CITY OF PORTLAND, MAINE

ZONING BOARD OF APPEALS

October 31, 1988

Receipt is hereby acknowledged of your application for a space and bulk variance to grant your request that the side and rear yard setbacks be waived to enable you to construct a three-car garage behind your residence at 19 Abbott Street in the R-5 Residence Zone.

19 Abbott Street

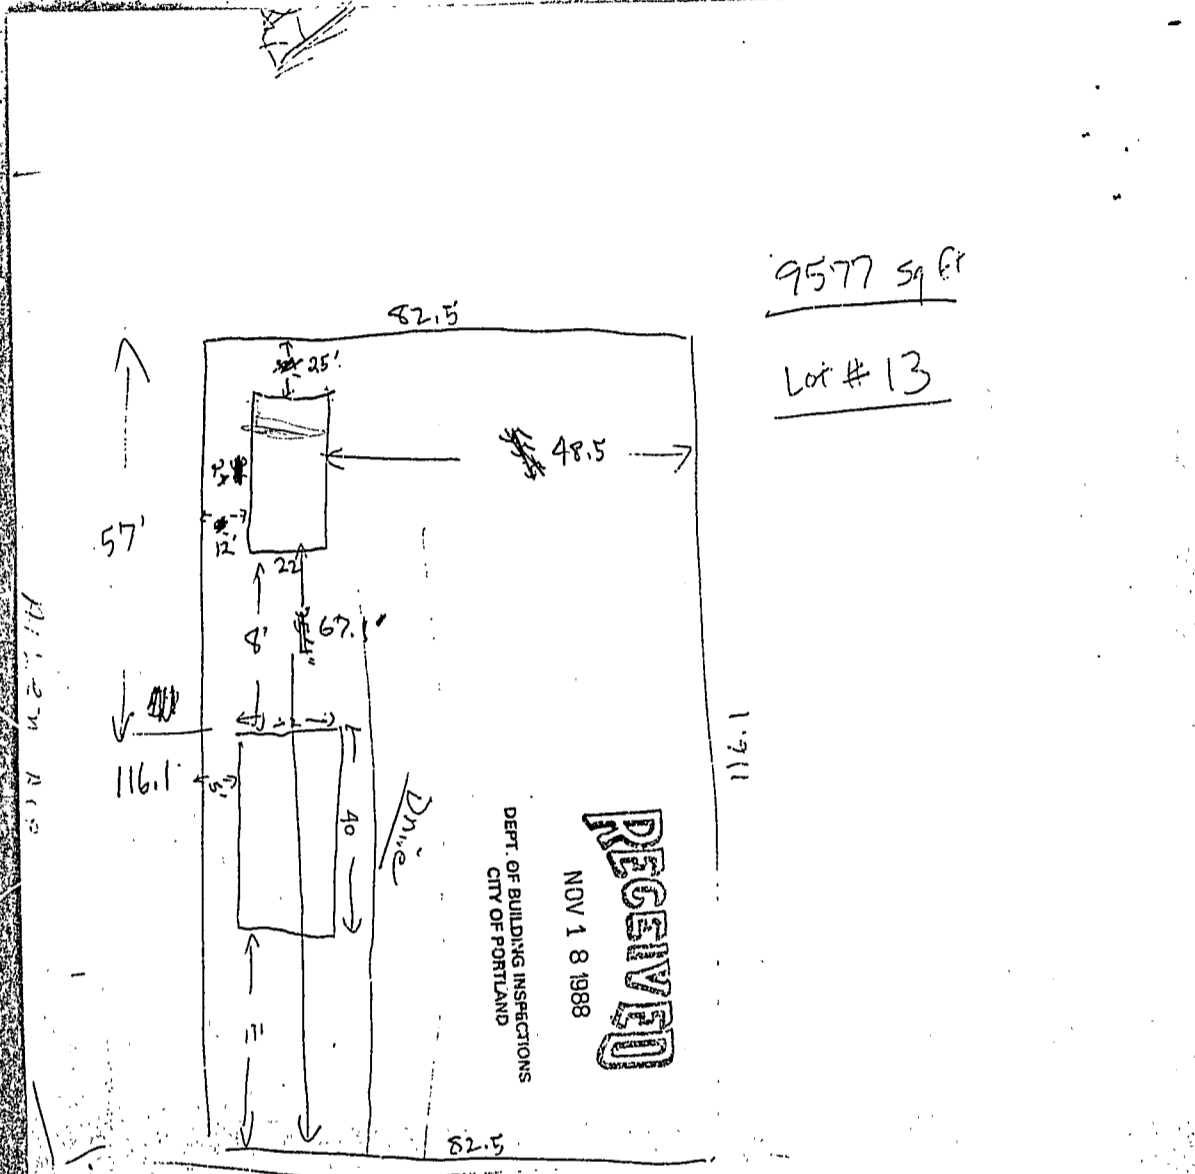
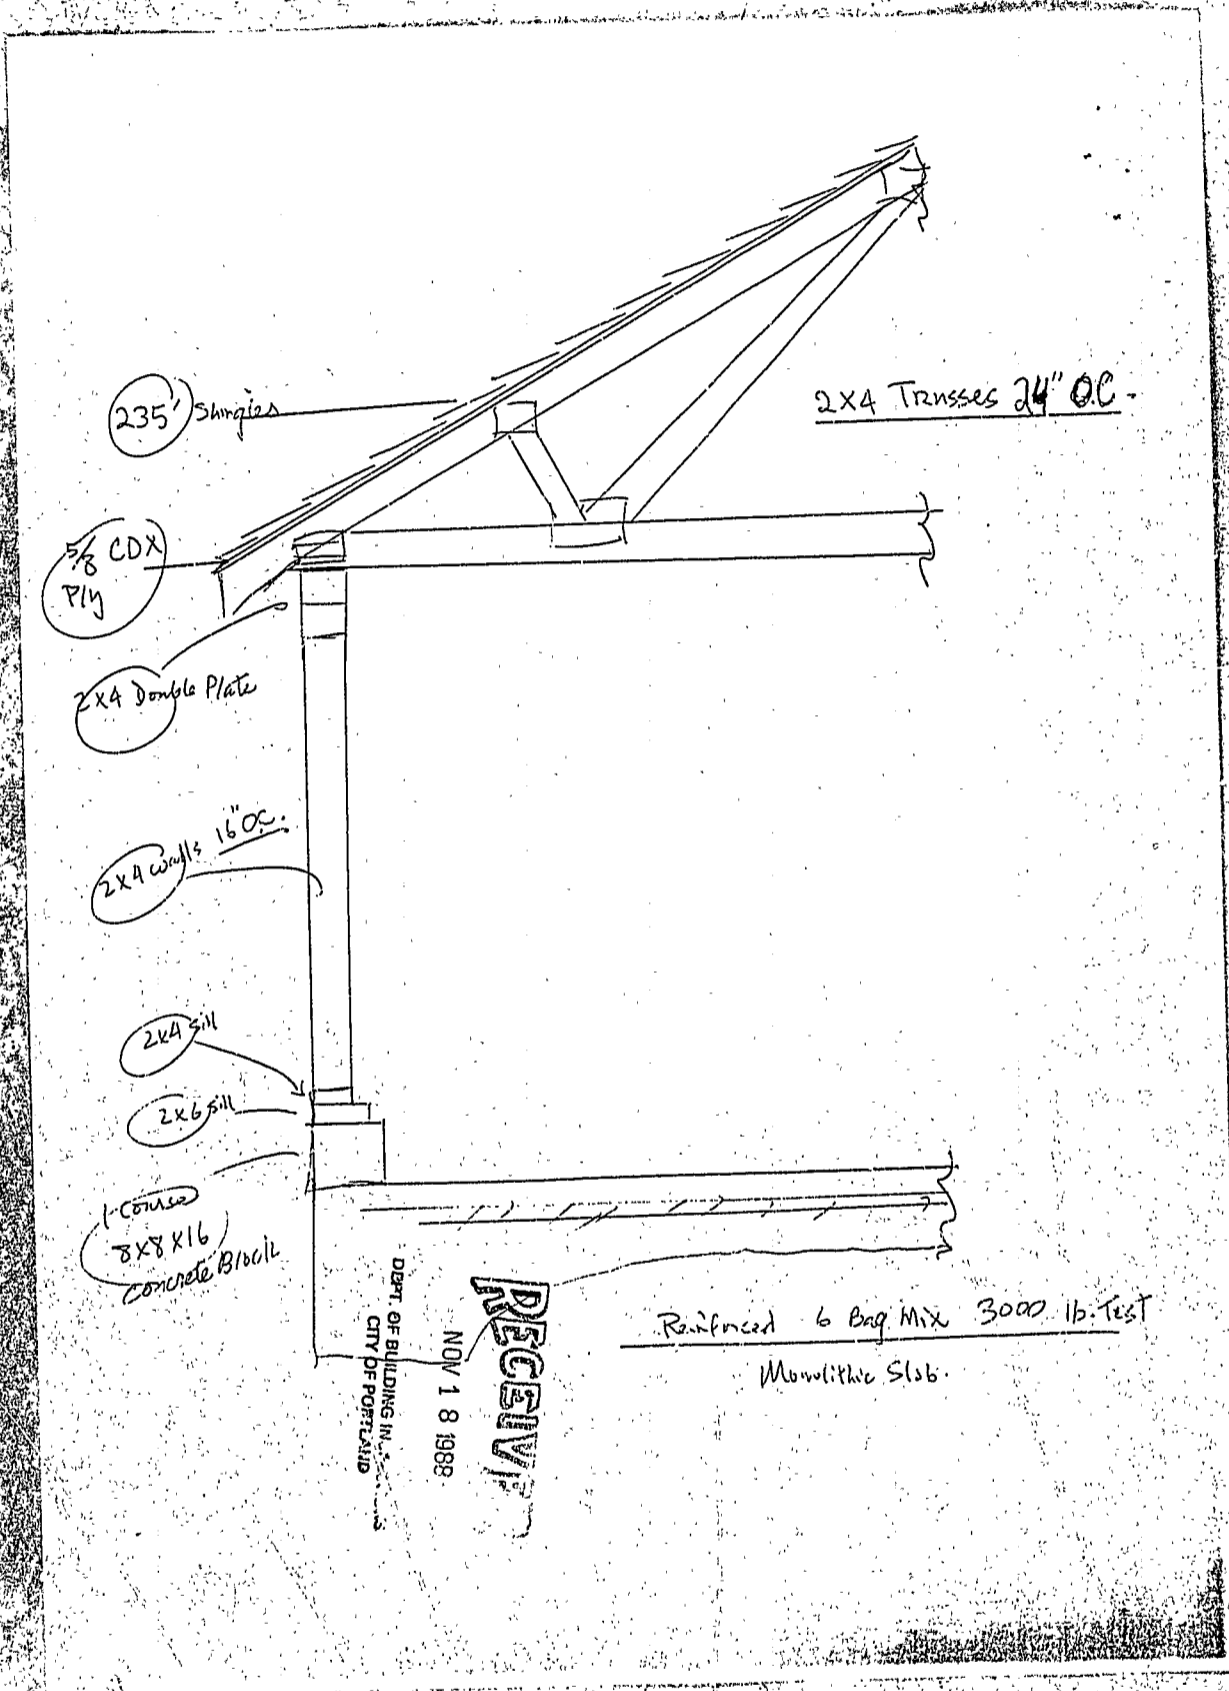
Section 120(4) of the City Zoning Ordinance requires that there be a 12 foot side yard setback for the proposed garage and 25 feet of rear yard setback instead of the five foot side and rear yard setbacks shown in your proposed plot plan for this project.
